Project EN070005: Southampton to London Pipeline Project
Interested Party: Nick Jarman, reference: 20022545

Attached is the Deadline 5 submission on behalf of the Neighbours and Users of Queen Elizabeth Park. This contains comments on responses to the ExA's Further Written Questions and comments on responses submitted for Deadline 4.

Deadline 5 Submission on Behalf of the Neighbours and Users of Queen Elizabeth Park

© Crown copyright and database rights 2020 OS Licence Number AL10005237

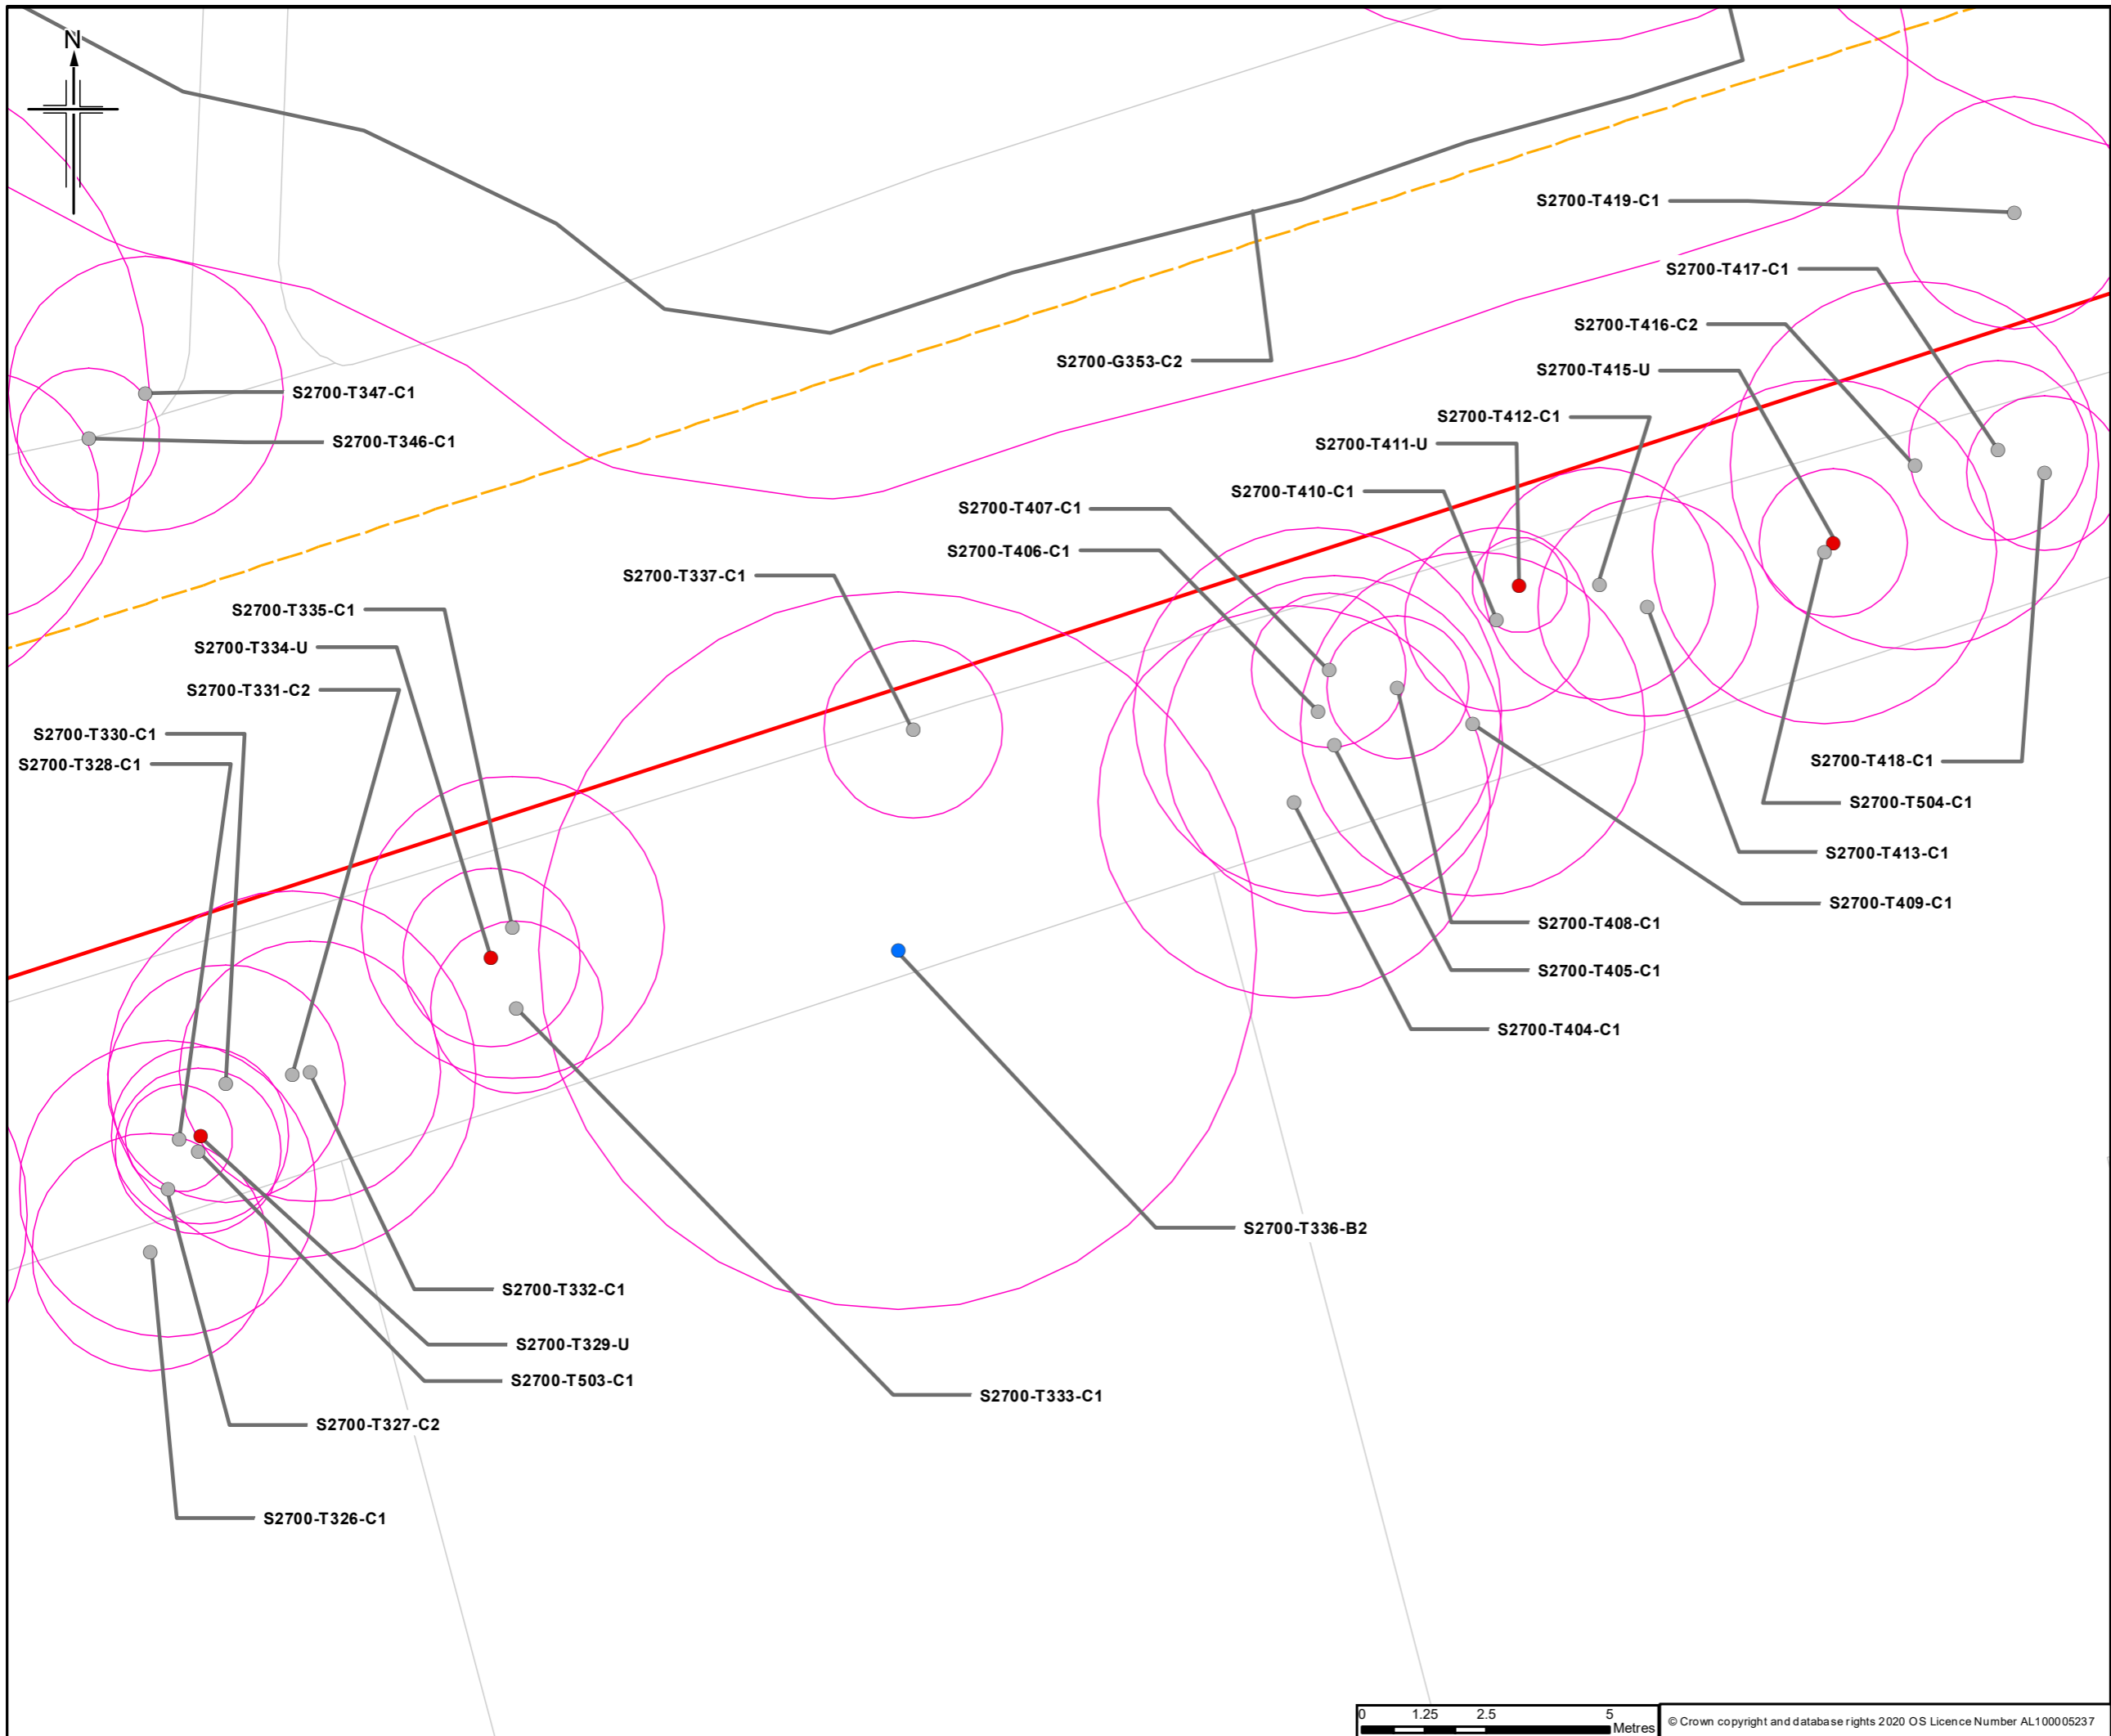
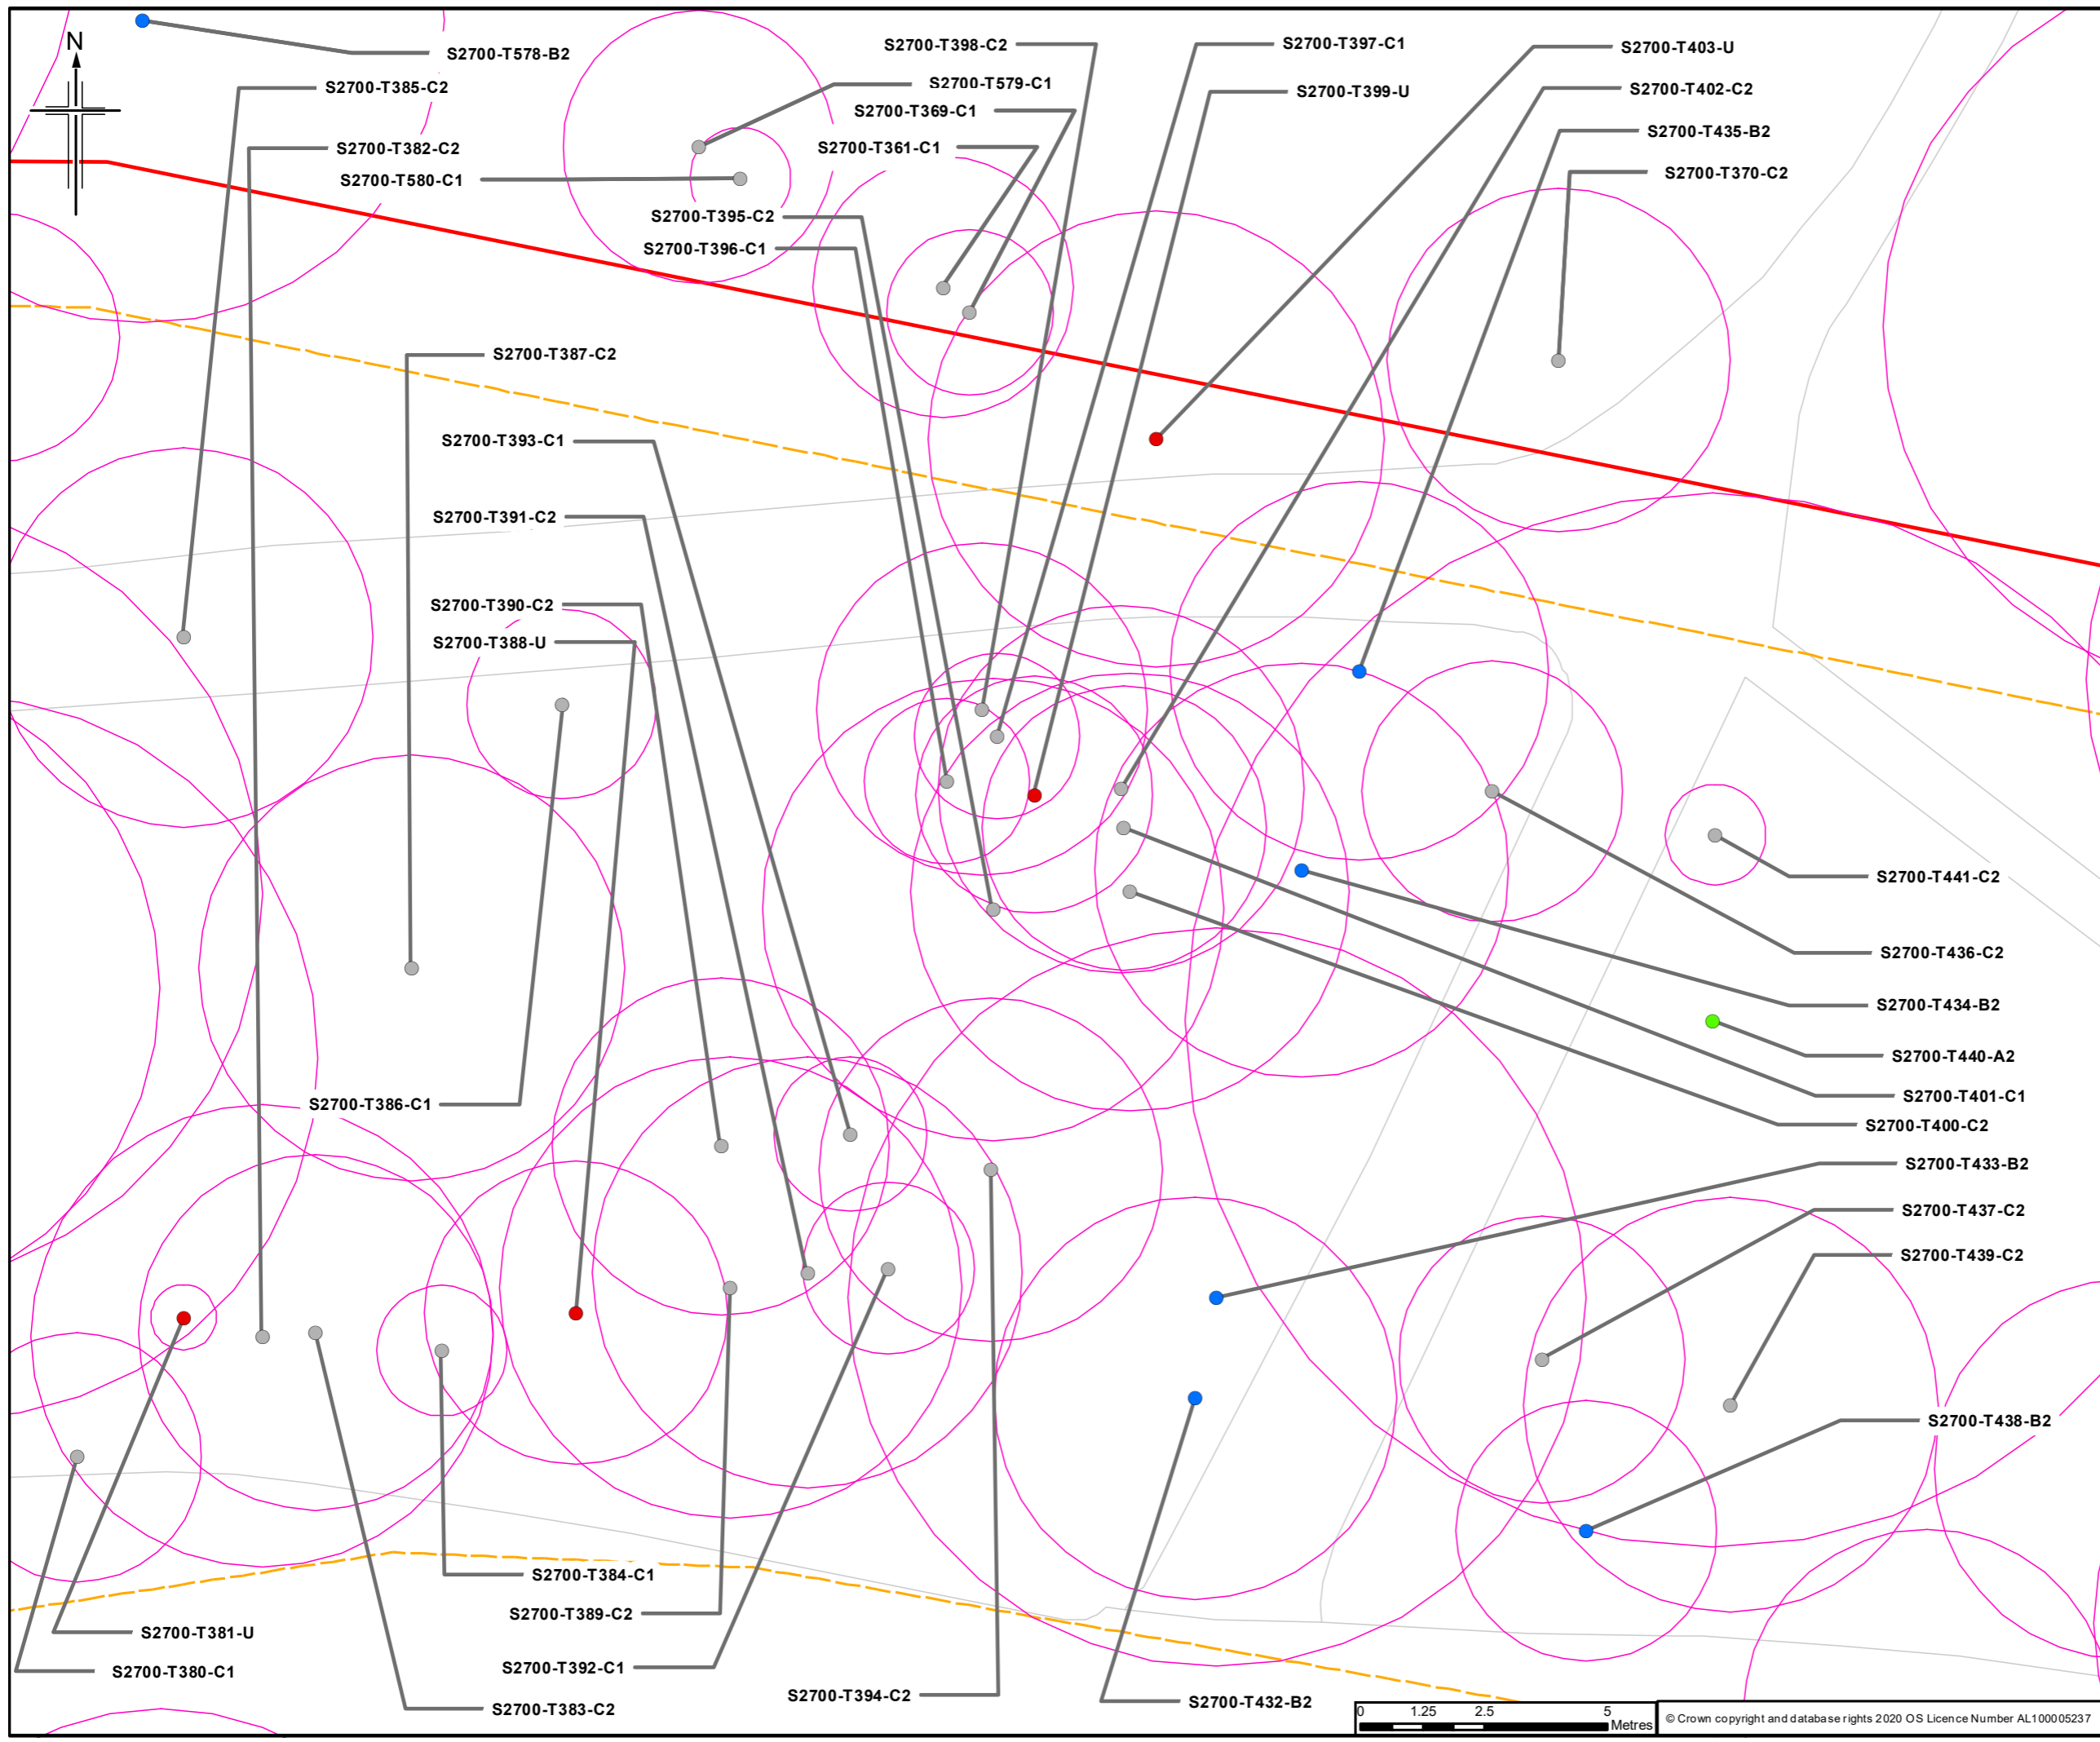
The tree survey lists over 580 trees (including groups), almost all of which are within the Order Limits. Although the survey is very comprehensive and mostly accurate, Esso omitted to identify which trees were classified as Notable or Veteran in the Woodland Trust's Ancient Tree Inventory (ATI). In the absence of this information, we have completed the work to map the Notable and Veteran Trees on the survey.

We have produced annotated versions of sheets 1-5 of the Queen Elizabeth Park Arboricultural Survey drawings, showing all trees listed in the ATI. These can be found in Appendix B. Extracts from these drawings are also used to illustrate specific points in the sections which follow.

Whilst we have not checked every single tree in the survey, we noticed a number of minor inaccuracies whilst we were correlating the survey with the ATI:

1. Path position near T432 and T433 - these trees are on the other side of the path.
2. T249 is listed as a sweet chestnut but is actually an oak.
3. A Notable Tree within the proposed Cabrol Road construction compound has been omitted.

We estimate that the total length of trench in the park is 532 metres, of which 472 is in narrow working area NW17. This is the length required to connect the TC018 pit to the proposed auger boring pit for TC019. 197 metres of the proposed trench is in root protection areas of Notable and Veteran Trees. That is 37% of the entire trench length within the park.

The root protection areas of 12 Notable Trees and 2 Veteran Trees will be violated by trench digging for the pipeline route as proposed. This will cause damage to the root systems and in many cases it is highly likely to kill the tree. BS5837:2012 states that:
